Department of Transportation

I-25
El Paso County

RE: VR1818 Gleneagle Golf Course Residential Infill Dev Fil no. 2 - **REVISED**

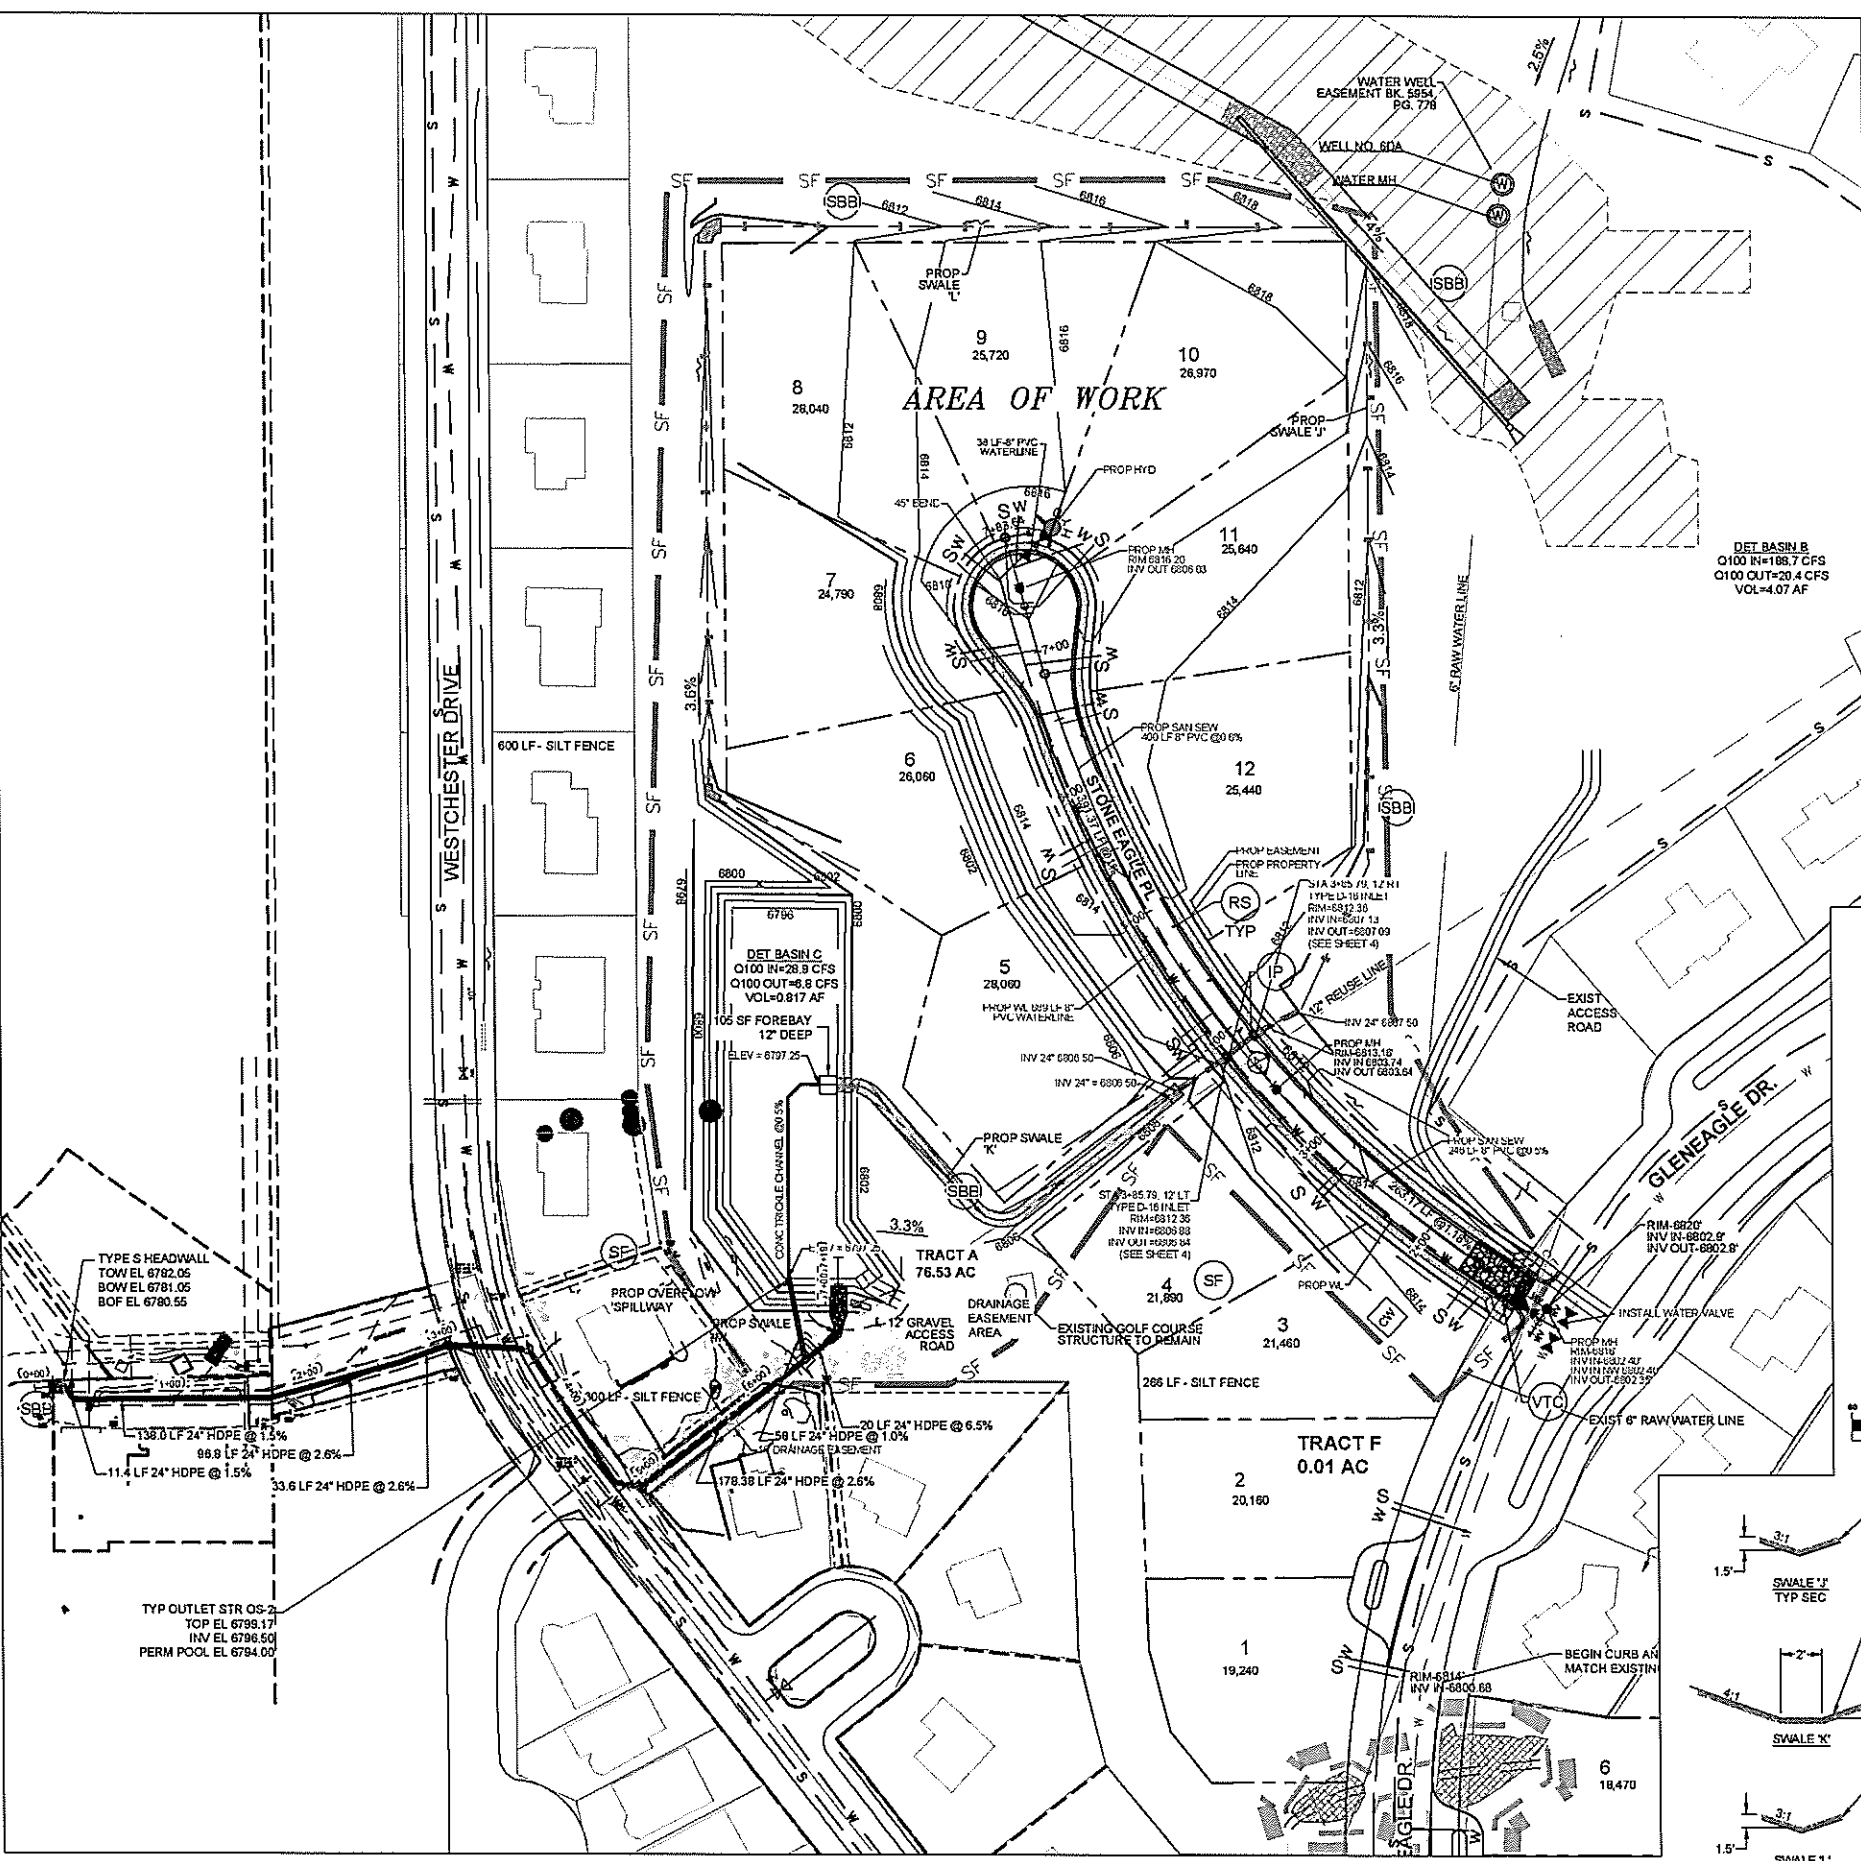
- Hydraulics comments are:
 - a. That Sheets 2 and 3 of grading plan - please provide outlet protection such as a riprap pad at the outfall into the existing ditch (STA: 0+00)

- e. Sheets 2 and 3 - Does the City/County allow bends in storm lines without a manhole?
 - f. Sheet 3 of grading plan, please show HGL and EGL for 5 and 100-year storm in profile.

VR-18-018 **SHEET 2**

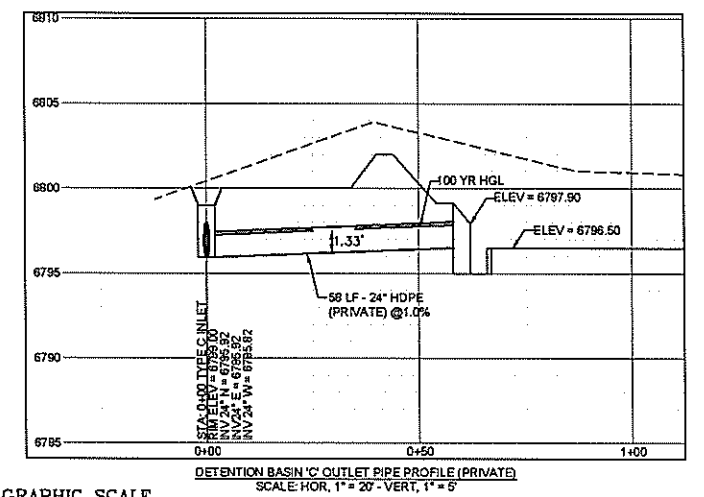
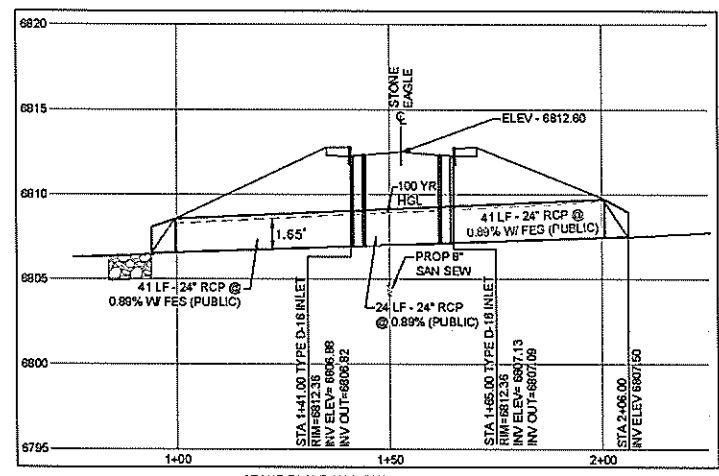
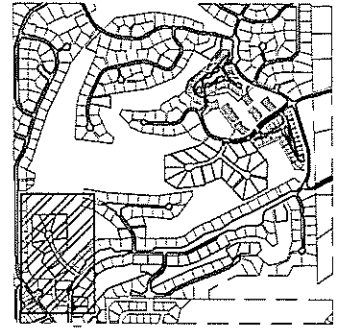
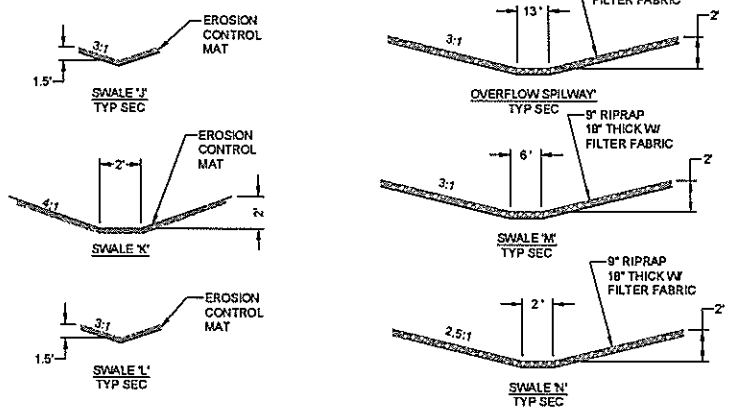
- g. Sheet 3 of grading plan, please show HGL and EGL for 5 and 100-year storm in profile.
 - h. Section D on sheet 4 of the grading plan shows an 18-inch outlet pipe. Should be 24" per other details and calculations.
